CITY OF ALBUQUERQUE

Re: route 66 Plaza, 8521 Central Ave NE
Request for Certificate of Occupancy
Transportation Development Final Inspection
Engineer's/Architect's Stamp dated 05-17-16 (K19-D043)
Certification dated 06-14-18

Based upon the information provided in your submittal received 10-26-2018, Transportation Development cannot approve the release of Certificate of Occupancy for the above referenced project.

ROUTE 66 PLAZA

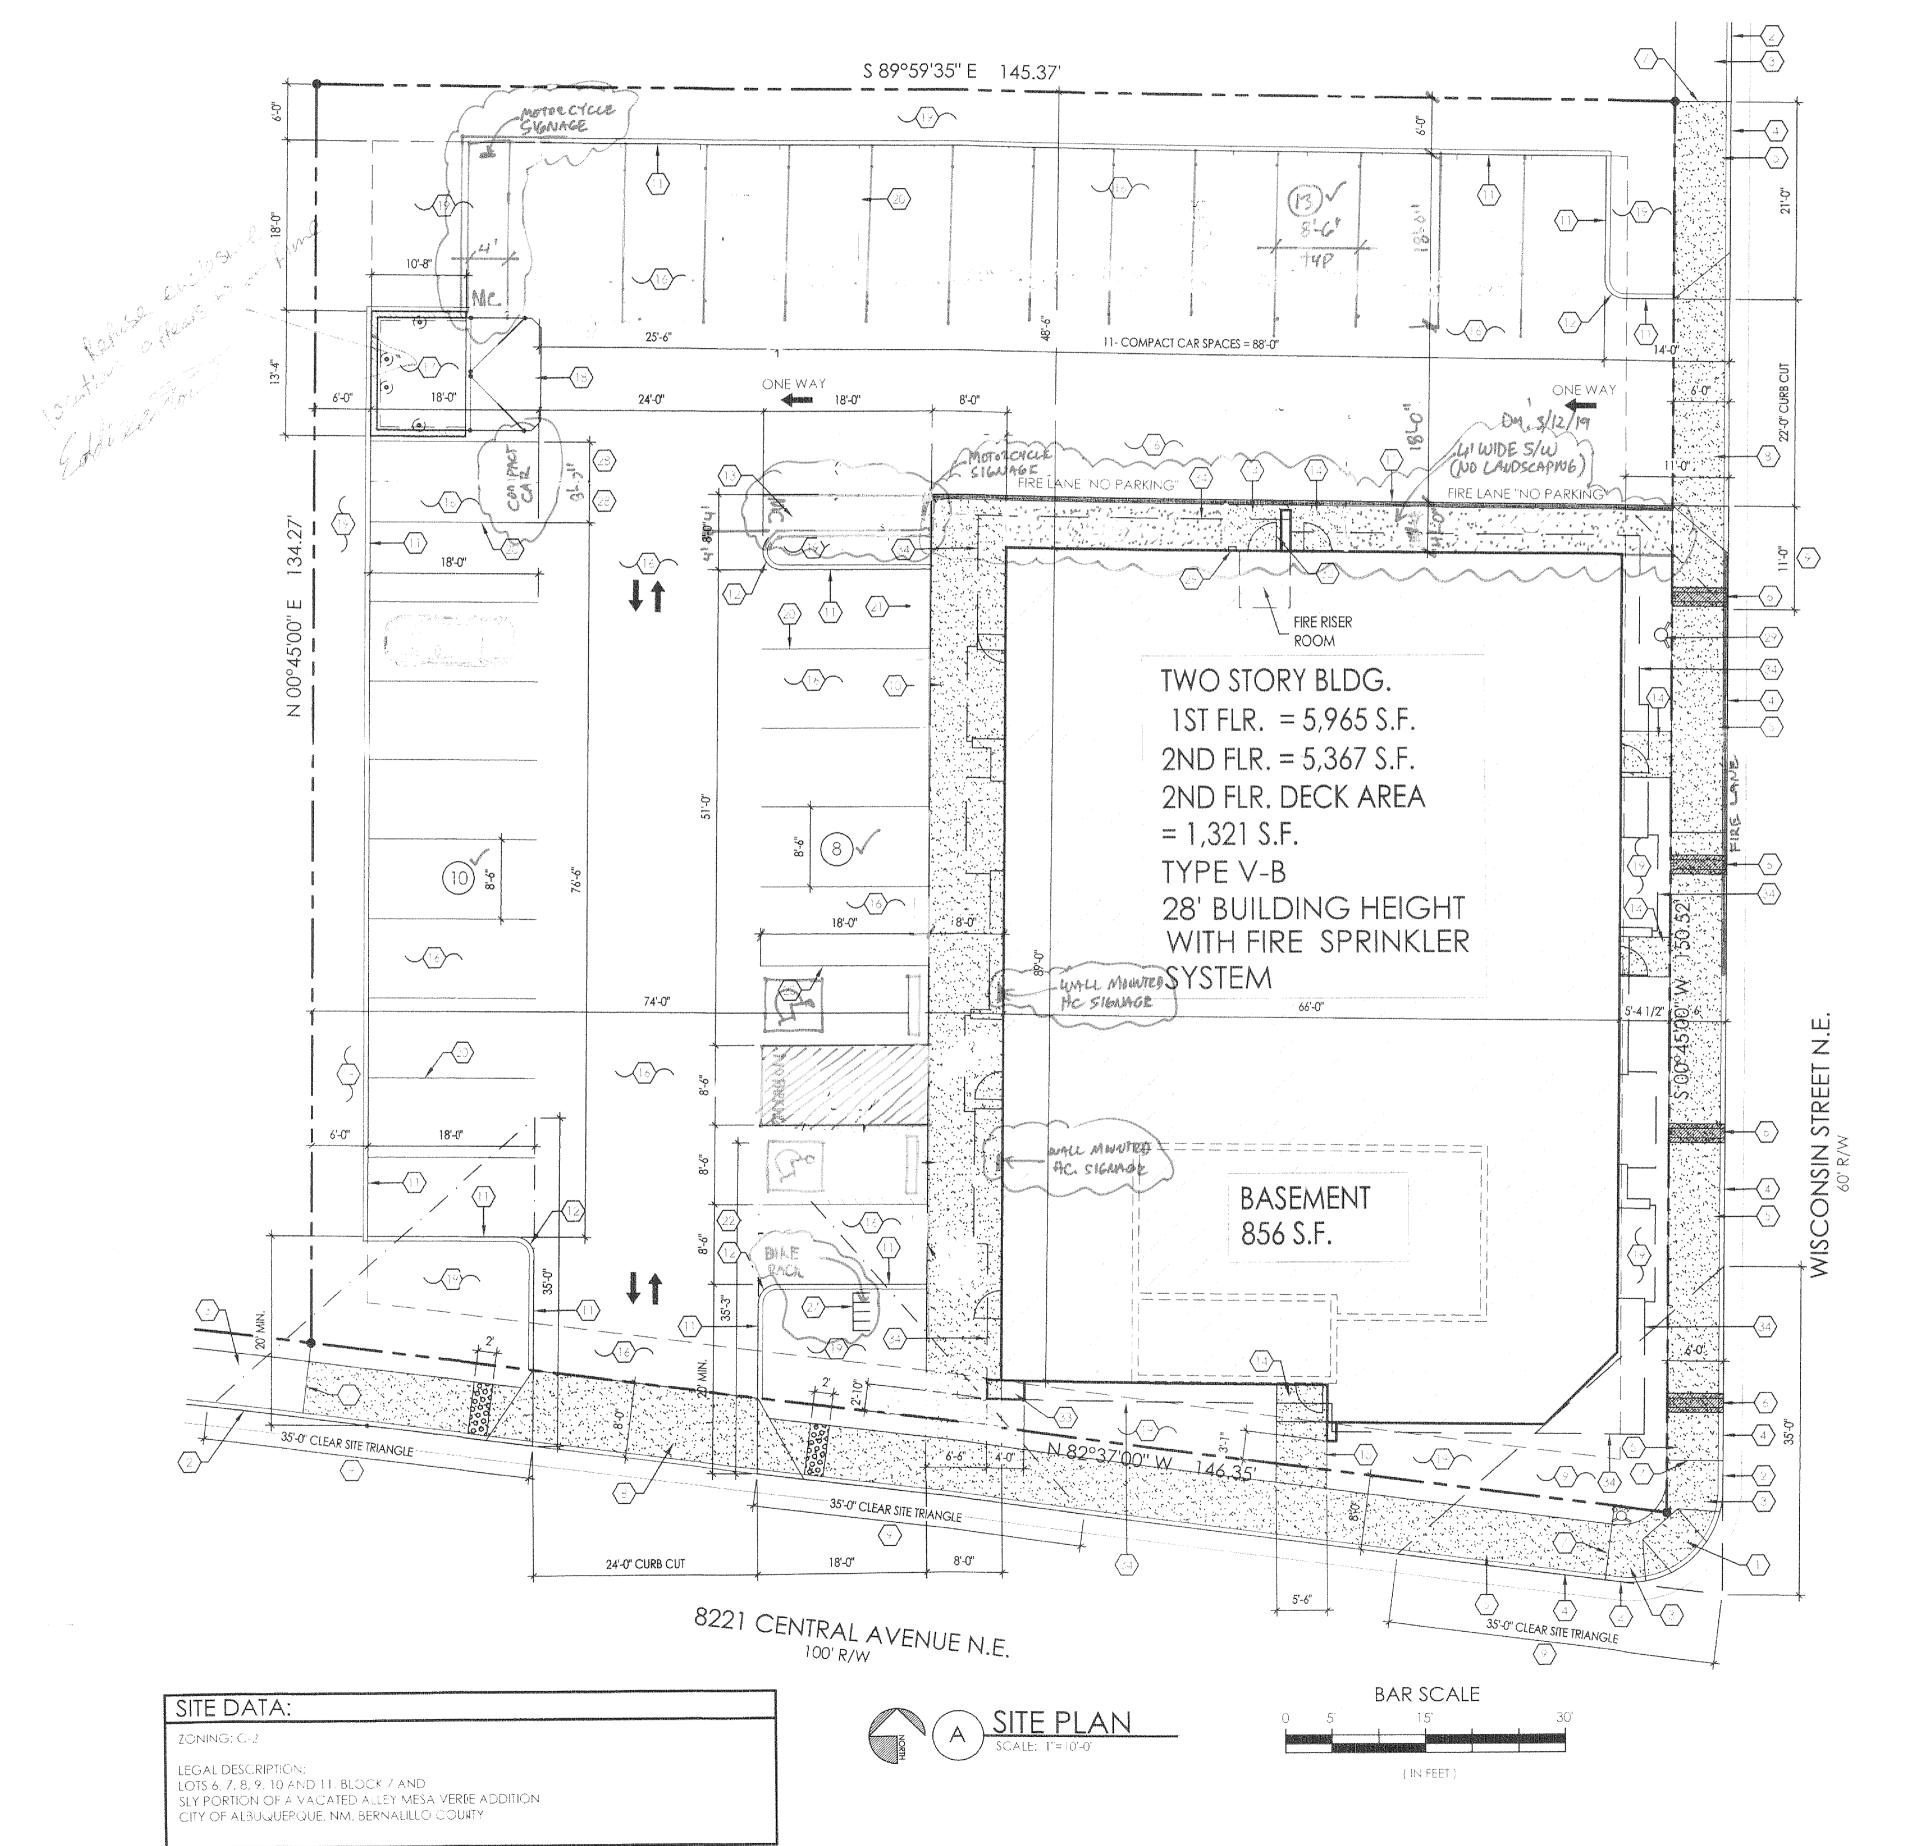
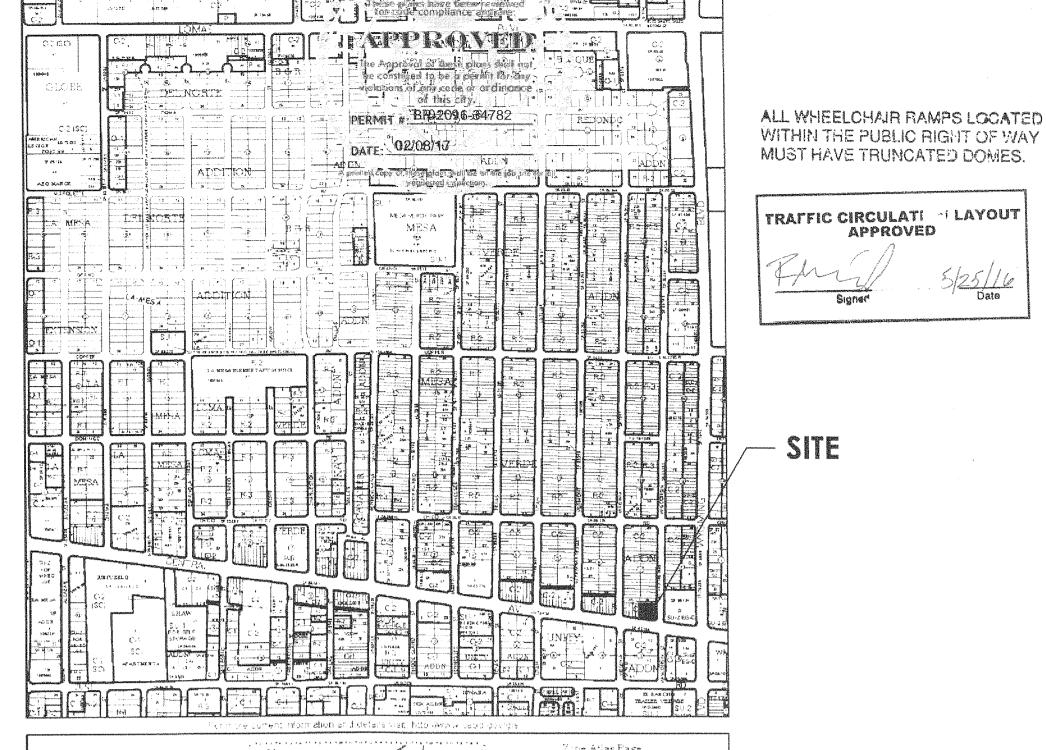
1. The address of the site is wrong on DTIS form, traffic certification letter, and the TCL. Please verify that.
2. There exists a large hole on the SW corner of the property. Please fix that.
3. Add bike rack to the site.
4. Add a 4' side walk connection on north end of the building due to deletion of the connection to central.
5. Add "Fire Lane No parking" to fire lane curb markings.
6. Add one-way markings to east entrance.
7. Fix fence at Southeast corner.
